Statement of Common Ground with Wiltshire Bridleways Association (Clean)

Planning Inspectorate Reference: EN010168

Document Reference: EXAM/8.17

This Statement of Common Ground has been prepared and agreed by Lime Down Solar Park Limited (the Applicant) and Wiltshire Bridleways Association.

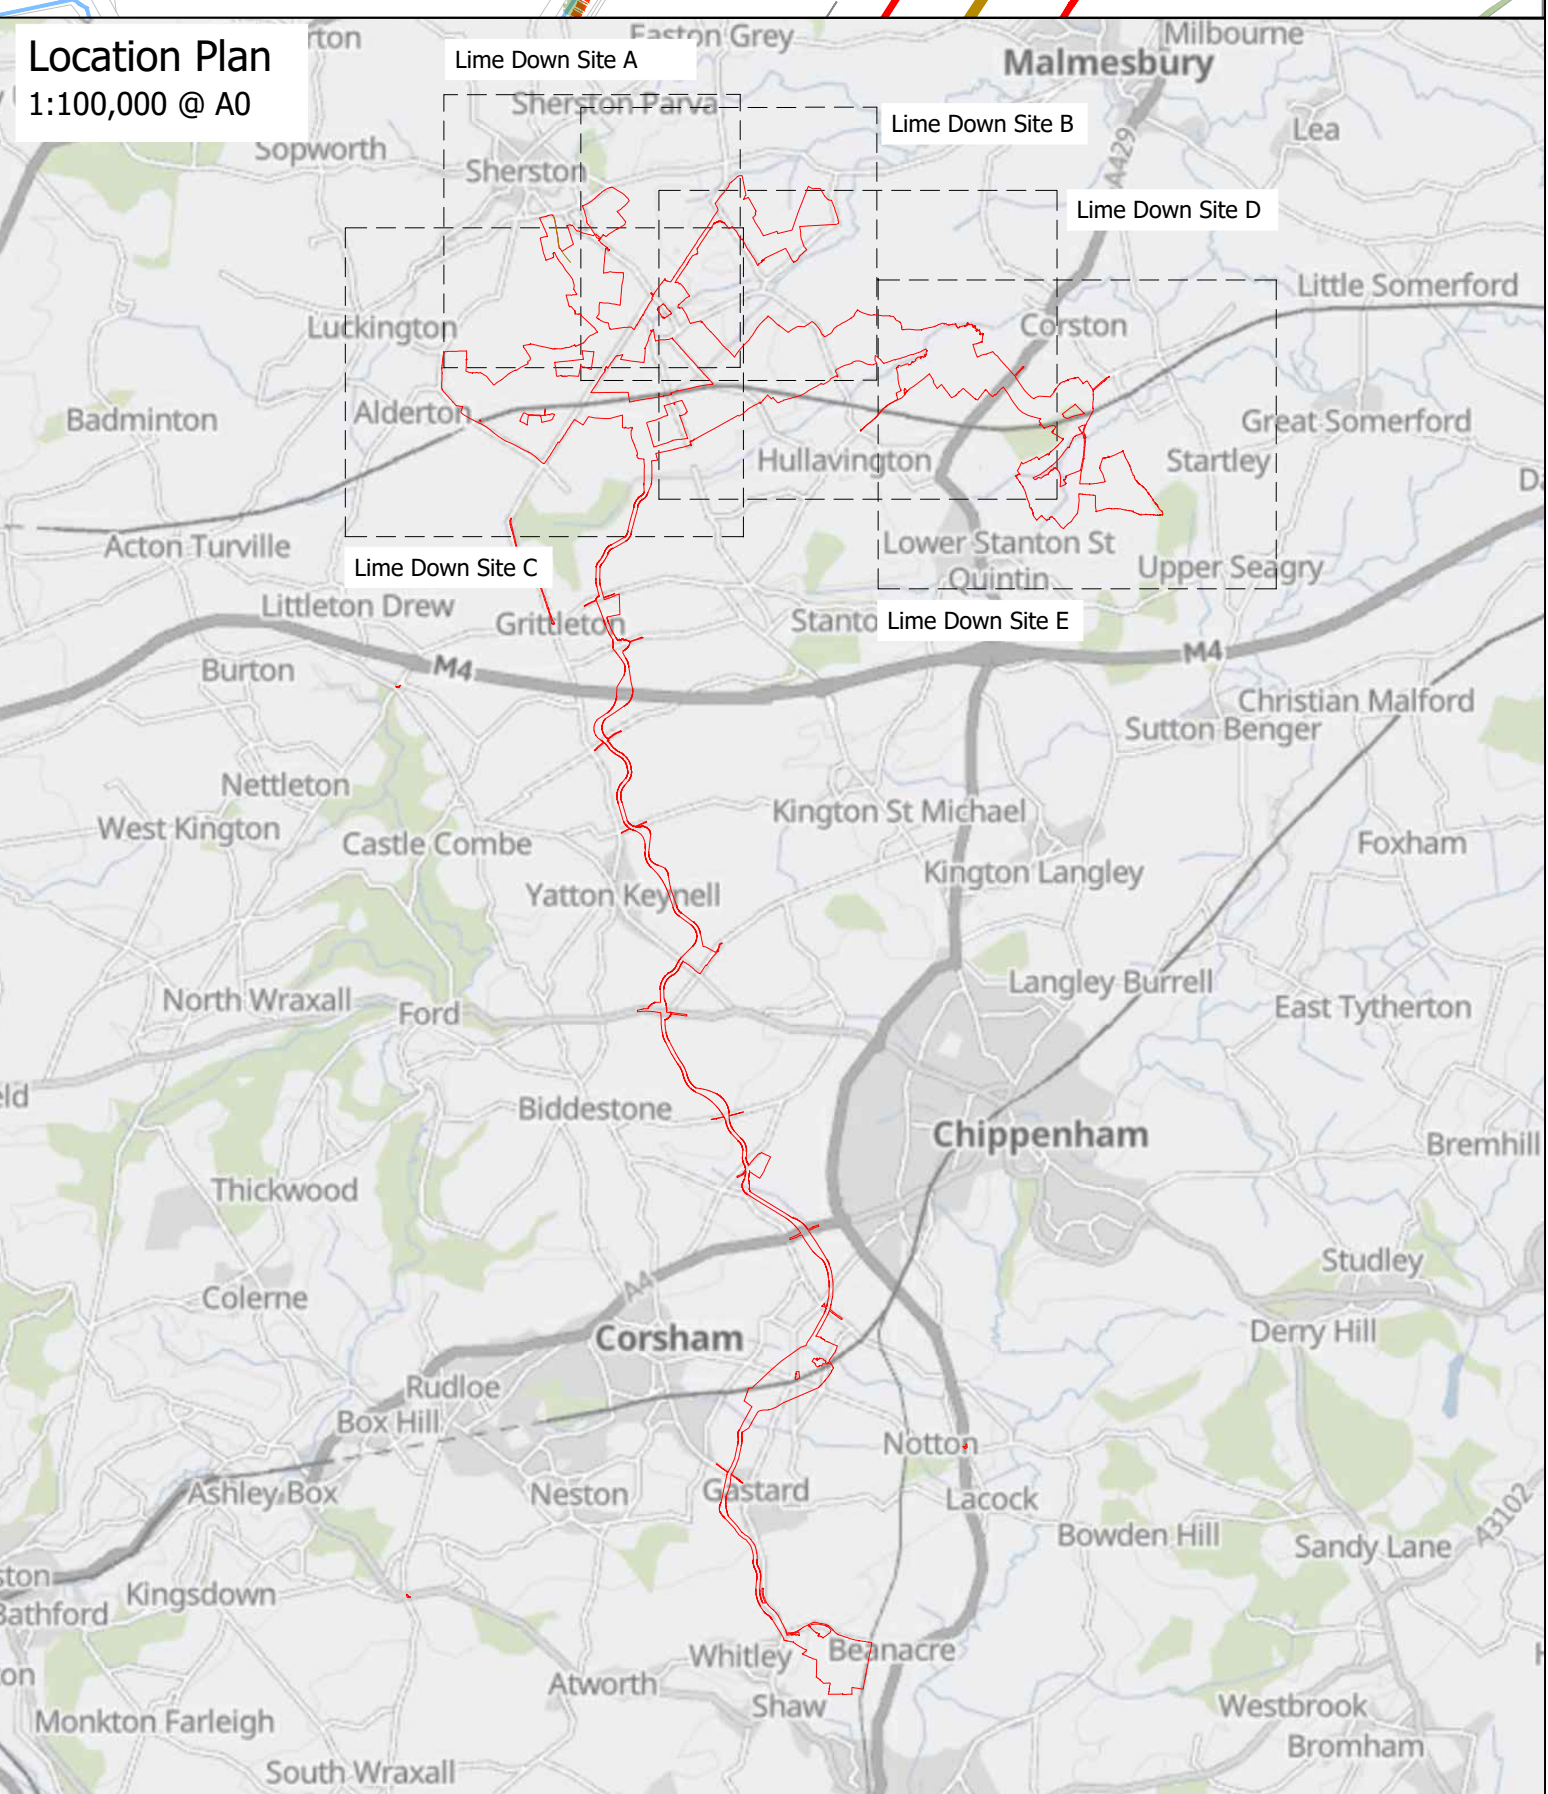
3.1.11	Mitigation - Fencing	The WBA would like the minimum path width to follow British Horse Society guidance at 3 metres and for fencing to be of vegetation rather than corrugated metal which would make the paths feel narrower.	A minimum surface width of 3 m is proposed for bridleways, as recommended by guidance from the British Horse Society. However, only groundcover planting will be planted immediately alongside PROWs, allowing users to pass at a greater	Agreed

Reference	Sub-topic	WBA Position	Applicant's Position	Status
		Updated position WBA accepts that a 3m width for bridleways is inline with BHS recommendations and will be sufficient.	width if required. Where new hedgerow planting is proposed alongside PROWs, this will be planted to maintain a suitable passable width that is to be determined at the detailed design stage. This is shown indicatively on ES Volume 2, Figures 3-4-1 to 3-4 5.2: Landscape and Ecology Mitigation Plan [REP-029 to REP1-032]. The majority of site fencing is to consist of 2 m deer stock fencing (i.e. wooden posts with wire mesh) set a minimum of 15 m from the centreline of the nearest PROW. Metal palisade fencing is only proposed in locations where there is a danger to life, and so is limited to substation and BESS enclosures. Palisade fencing is not proposed adjacent to PROWs. These principles (including offsets to PROWs, PROW widths, and fencing and PV types), are set out in the Design Principles and Parameters [REP1A-008] and indicatively shown on the ES Volume 2, Figures 3-4-1 to 3-4 5.2: Landscape and Ecology

Reference	Sub-topic	WBA Position	Applicant's Position	Status
			Mitigation Plan [REP-029 to REP1-032] All details of the Scheme are subject to the relevant Requirements in Schedule 2 the Draft DCO [REP1-007].
